Your Reference: MP 11_0046
 Our Reference: NCA/4/2012
 Contact: Kate Lafferty
 Telephone: 9806 5393
 Fax: 9806 5901

13 December 2012

**Major Project 11_0046 – Modification of Concept Plan MP05_0086 and the Construction of Stage 3 Residential Development – Buildings 11-17
 61 Mobbs Lane - Epping – former Channel 7 Site (Epping Park)**

DRAWING TITLE: LOWER GROUND 2	PROJECT NO:	DATE:	DRAWING No:	REV:
	697	MAY 2012		
	DRAWN BY:	SCALE:		
	GO	As indicated	A0001	1
	CAD FILE:

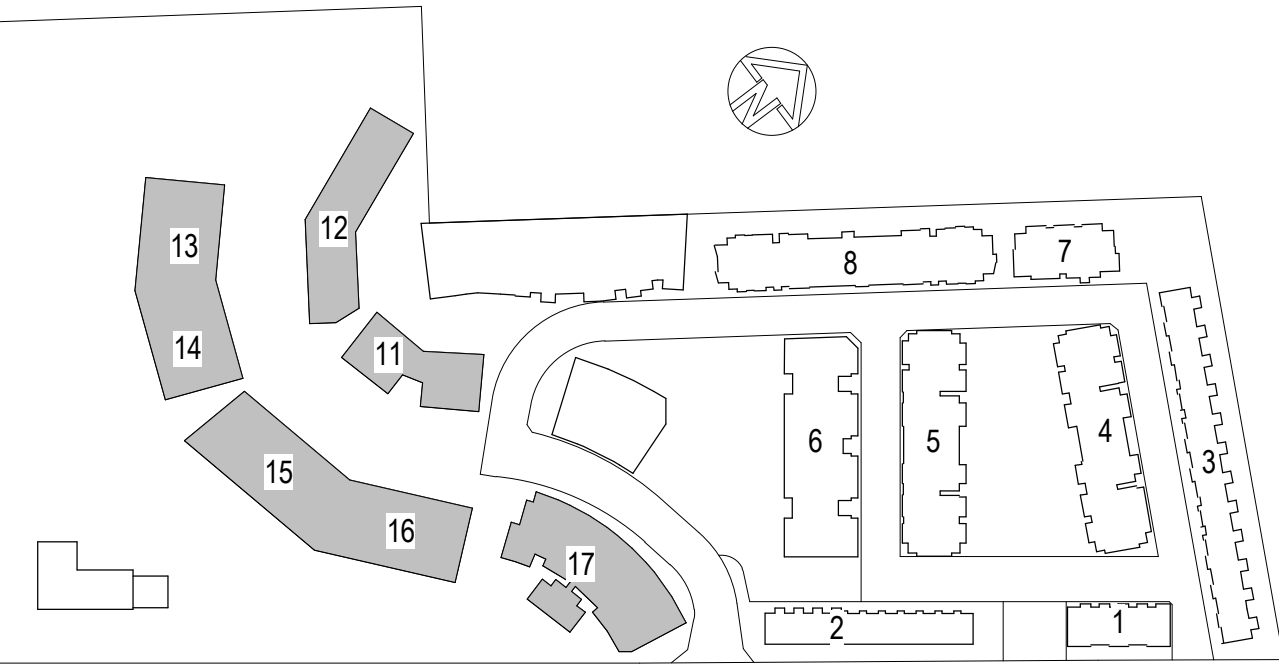
- The number of parking spaces provided on site should comply with the minimum requirement specified under the approved concept plan
- There are 2 disabled parking spaces that need to be provided with a shared space (one space located in the lower ground near the pedestrian egress point and one space located in the upper basement near stairs opposite the proposed stacked parking spaces). The dimensions and configuration of the disabled parking spaces are to comply with AS 2890.6-2009 (a dedicated space plus a shared space - 2.4m wide x 5.4m long each with a bollard installed on the shared space).

- There are a significant number of stacked parking spaces within the basement levels and this is not a preferable, or necessary design layout for a new development.

- The dimensions and configuration of the disabled parking spaces are to comply with AS 2890.6-2009 (a dedicated space plus a shared space - 2.4m wide x 5.4m long each with a bollard installed on the shared space)

SITE SECTIONS - 1

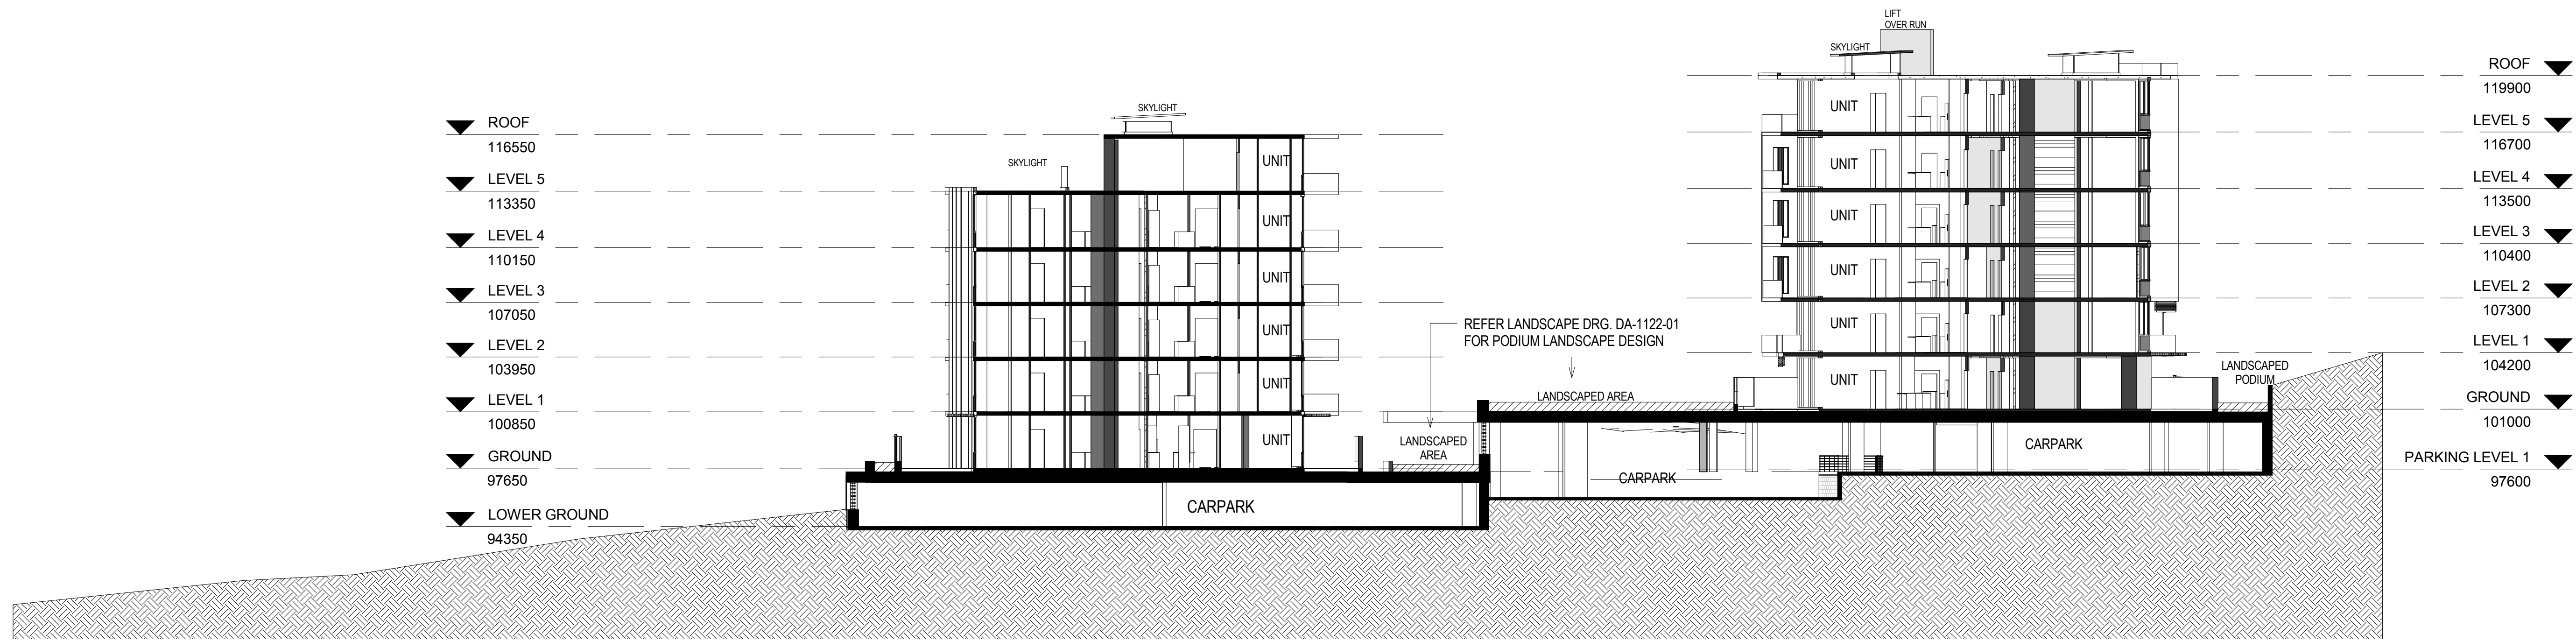
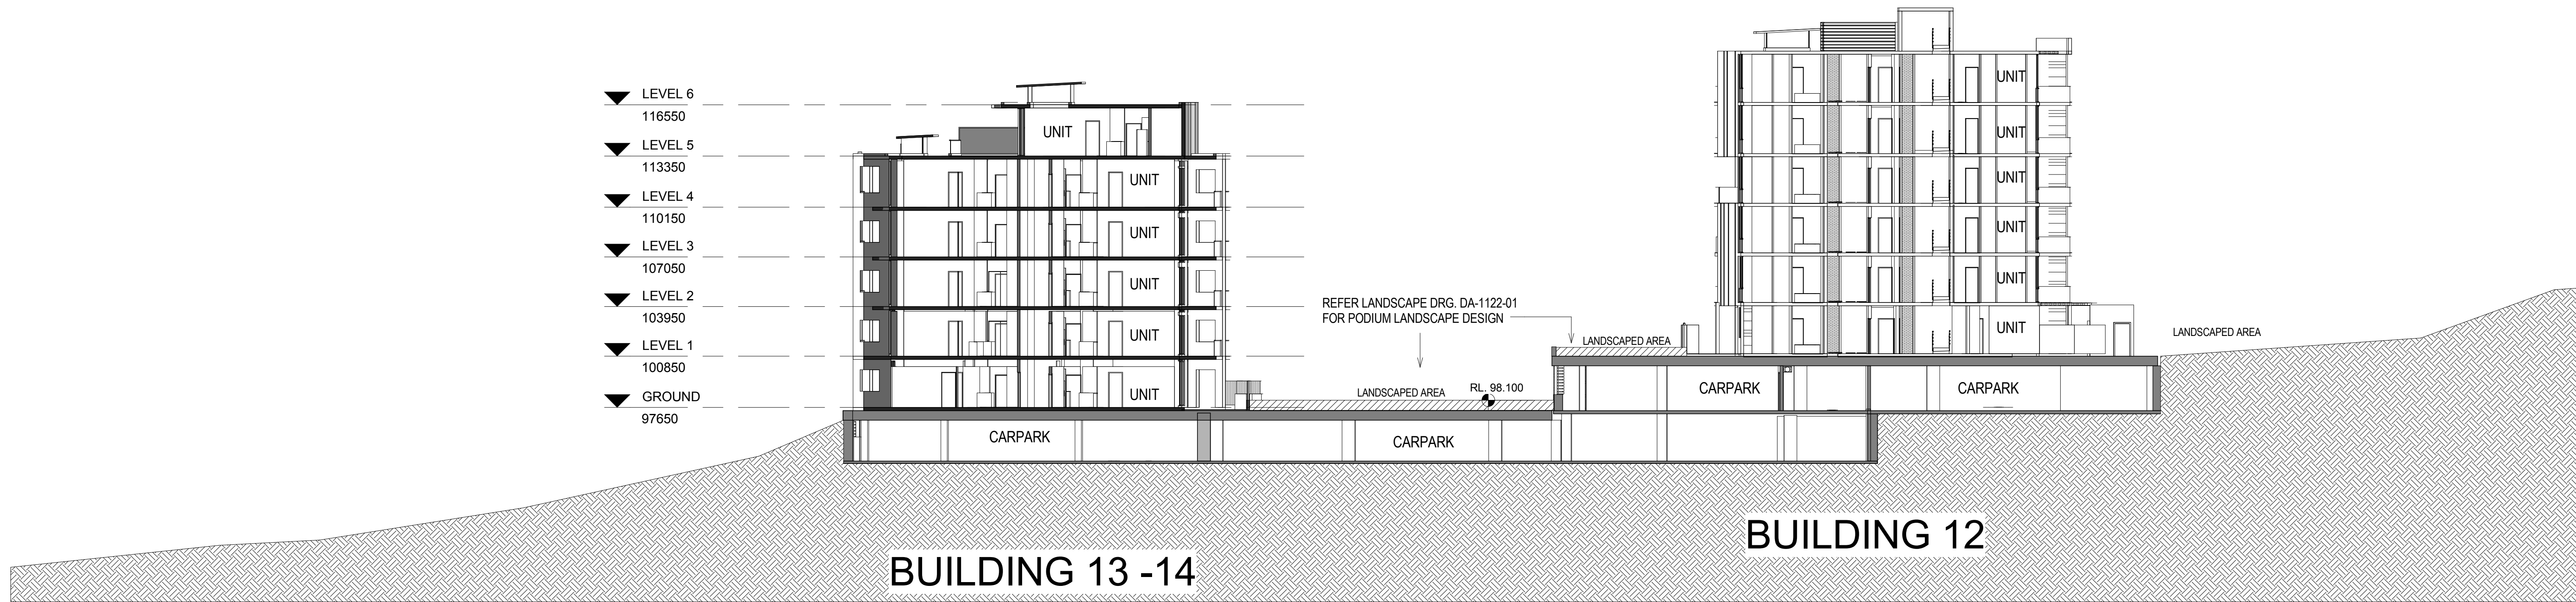
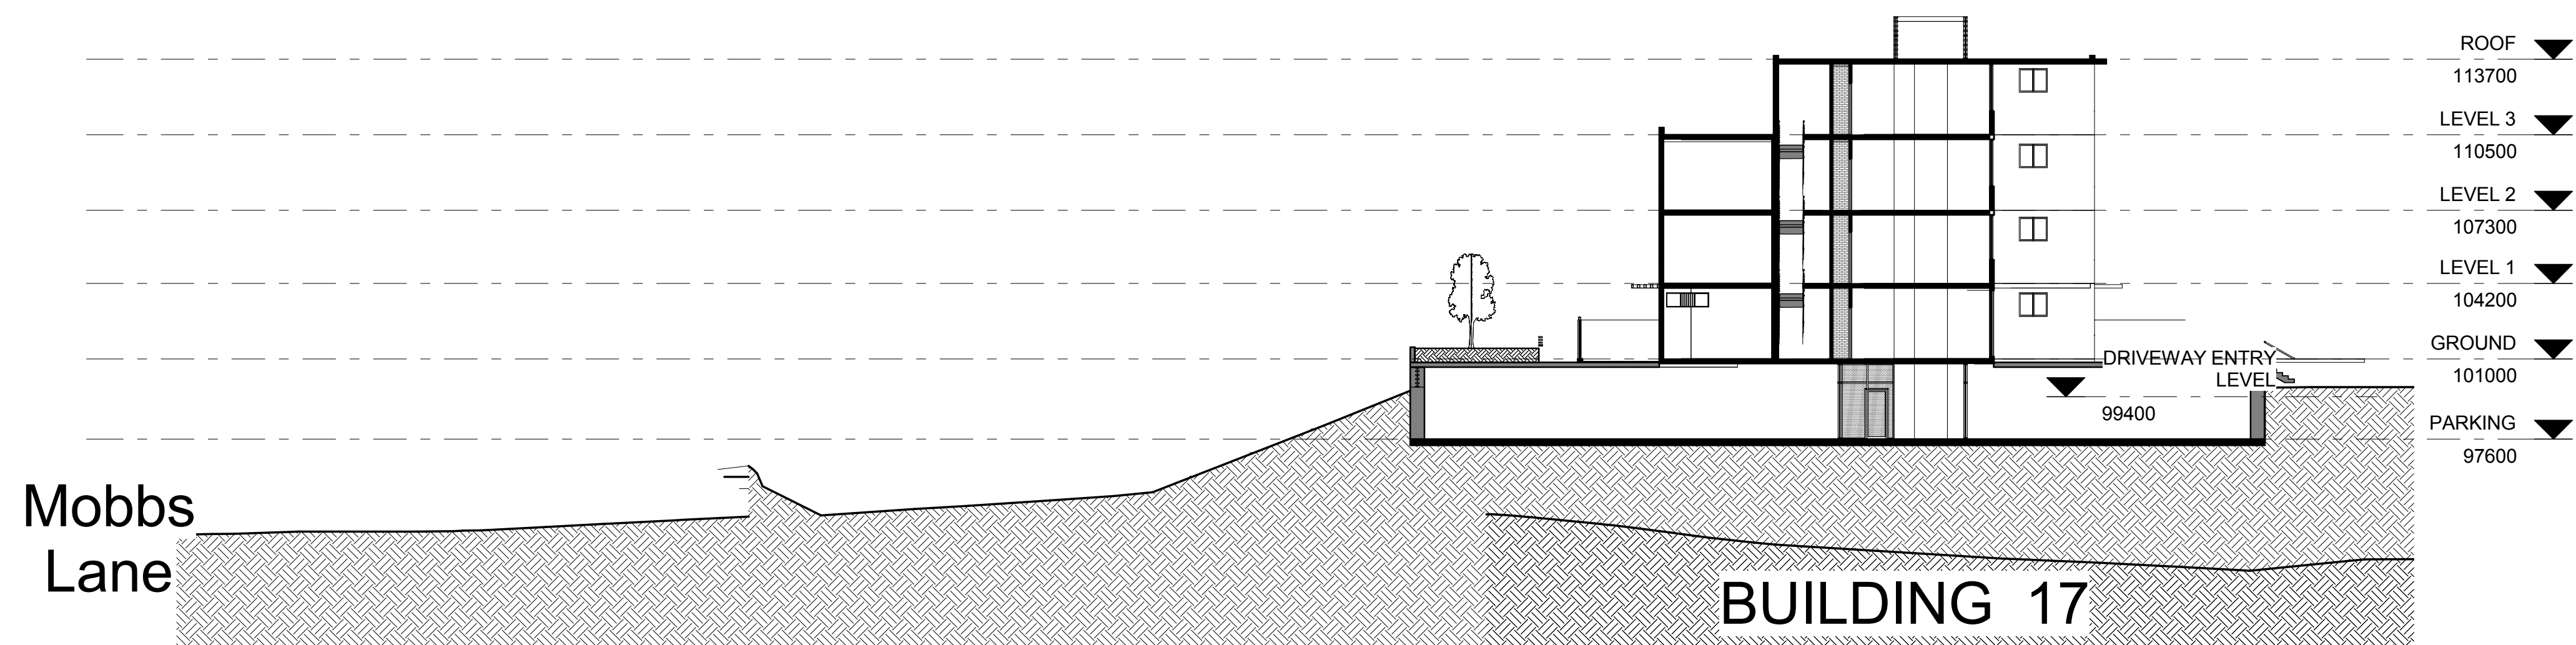
It is difficult to properly assess the heights of the buildings (particularly in terms of the basement projections) as no natural ground levels have been provided on the plans and the levels on the submitted survey cannot be ascertained. It is therefore considered that the Department of Planning and Infrastructure carry out the detailed assessment to verify compliance with heights.
